Our ref: NA/2020/115170/01-L01
Your ref: TR010059
Date: 29 October 2020

A1 IN NORTHUMBERLAND: MORPETH TO ELLINGHAM MORPETH TO ELLINGHAM RELEVANT REPRESENTATIONS (SEPTEMBER - OCTOBER)

We have reviewed the Development Consent Order (DCO) application, Environmental Statement (ES) and supporting documents and have a number of concerns regarding the proposed development and matters within our remit. We therefore make representations in relation to the following areas:

**Figure 5-6 - Proposed White House Burn Culvert**

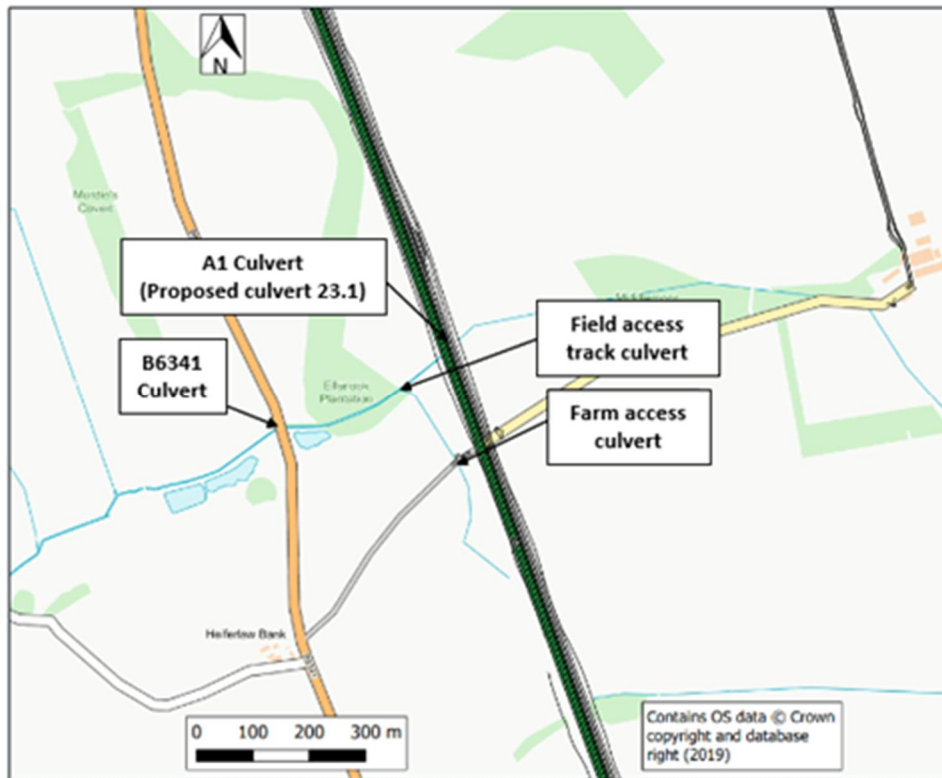
- Shipperton Burn where the step at the outlet to the culvert is a clear issue for fish migration and yet not mentioned nor addressed; and
- Kitty Carter Burn Southern crossing and White House Burn crossing are obvious pathways for nutrients and fine sediment to enter the watercourse. Despite listing these as WFD pressures for the relevant waterbodies, yet not considered and addressed.

**Figure 6-10 – Design of Realigned Tributary of Kittycarter Burn**

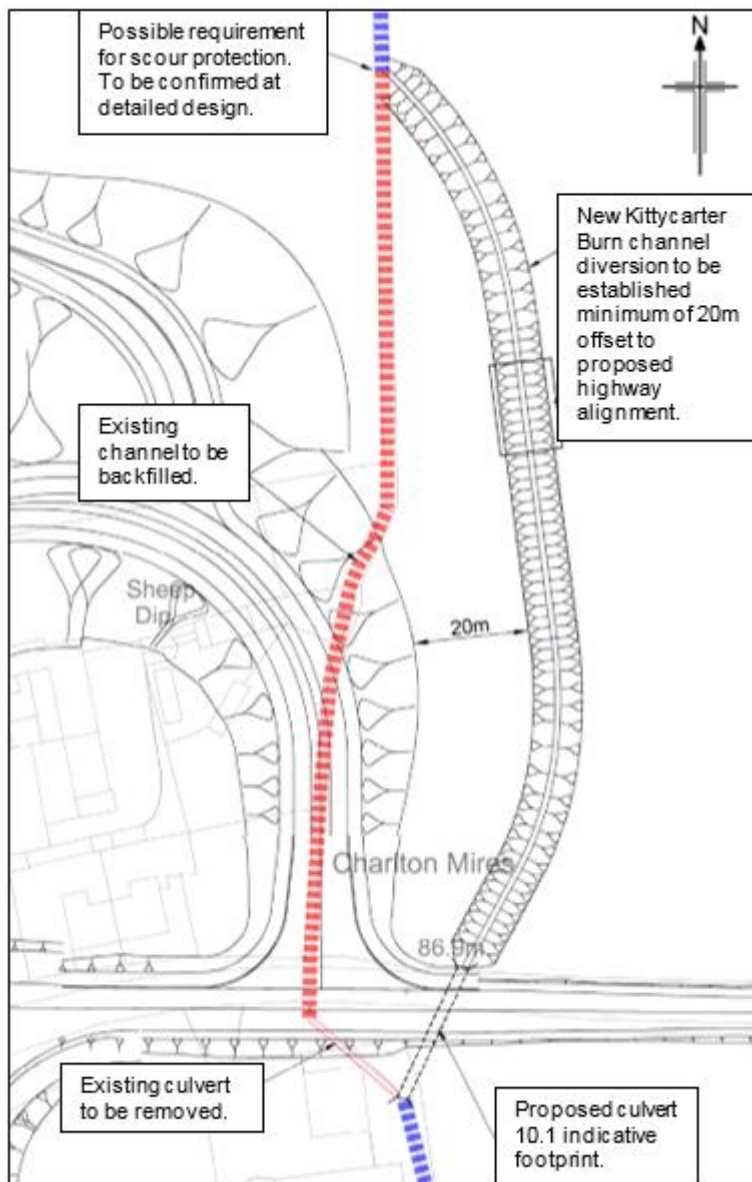
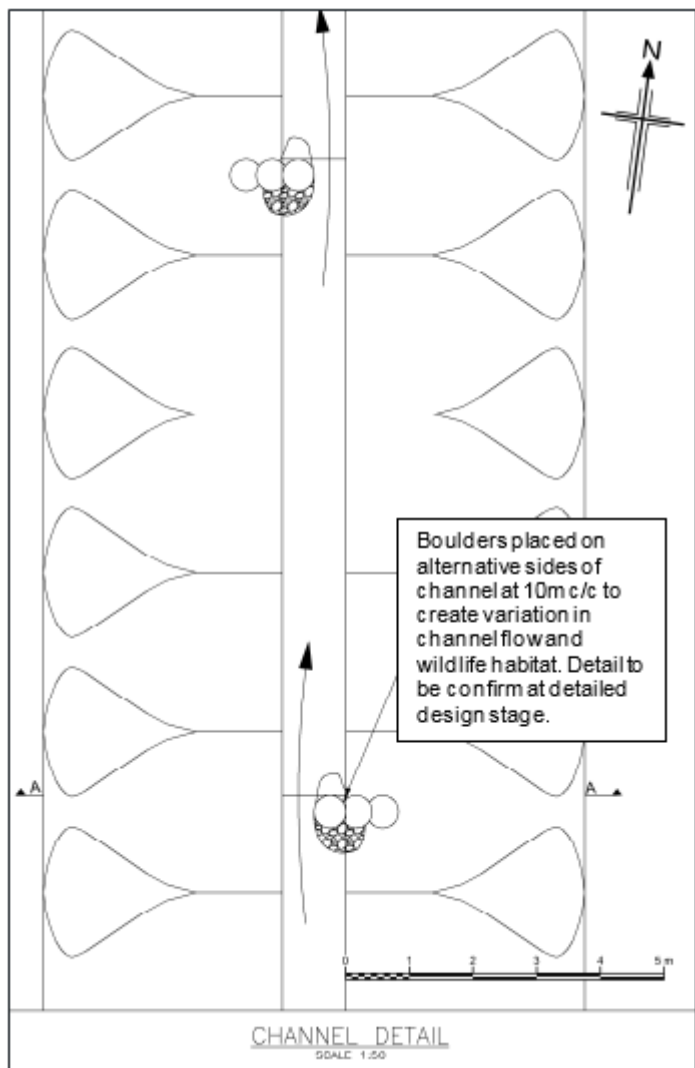
This is much greater than the 200m the ES summarises. It is assumed that the applicant has come to this conclusion due to the 540m of new channel due to be created as stated in section 9.9.6. However not only this is a net loss, but this is not a like for like replacement and channel realignments are unlikely to carry the same biodiversity value as previous channels. No designs for new channels have been submitted, and plans appear to show straightened channels, which provide a very low biodiversity value.

In Part A and B it is proposed to realign several watercourses. The design criteria “the design of the new channel would maintain a similar channel profile and dimensions to the existing watercourse to mimic existing conditions. Boulders would be placed within the new channel to provide varied substrate features and flow dynamics within the watercourse channel” is not acceptable. There is a clear opportunity for betterment, and we welcome the commitment to “further develop the design during the detailed design stage alongside further consultation with the Environment Agency and Northumberland County Council as Lead Local Flood Authority”.

Opportunities to create more natural, sinuous watercourses and water dependant habitats have not been considered, such as realignment of Fenrother Burn. As such, we believe there are many missed opportunities to compensate for the impact of the scheme, thus further increasing the biodiversity net loss.

To overcome our concerns, the applicant will need to carry out and submit a design of the mitigation and compensation of channel creation as part of the DCO. The design should be developed with a specialist geomorphologist support in order to maximise the biodiversity and hydromorphology benefits of the new channel alignments

**Figure 8-6 – Shipperton Burn Part B Proposal**

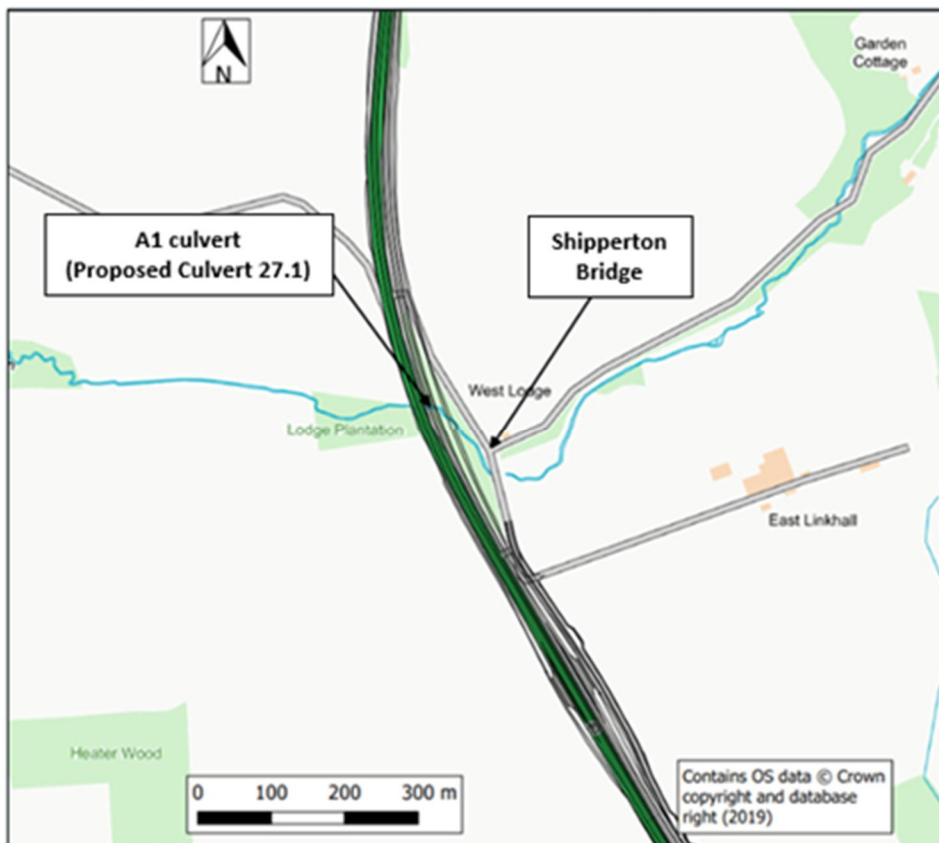
development of a natural bed within the structures, with the A1 culvert on the Shipperton Burn clearly showing a step and channel incision at the downstream end.
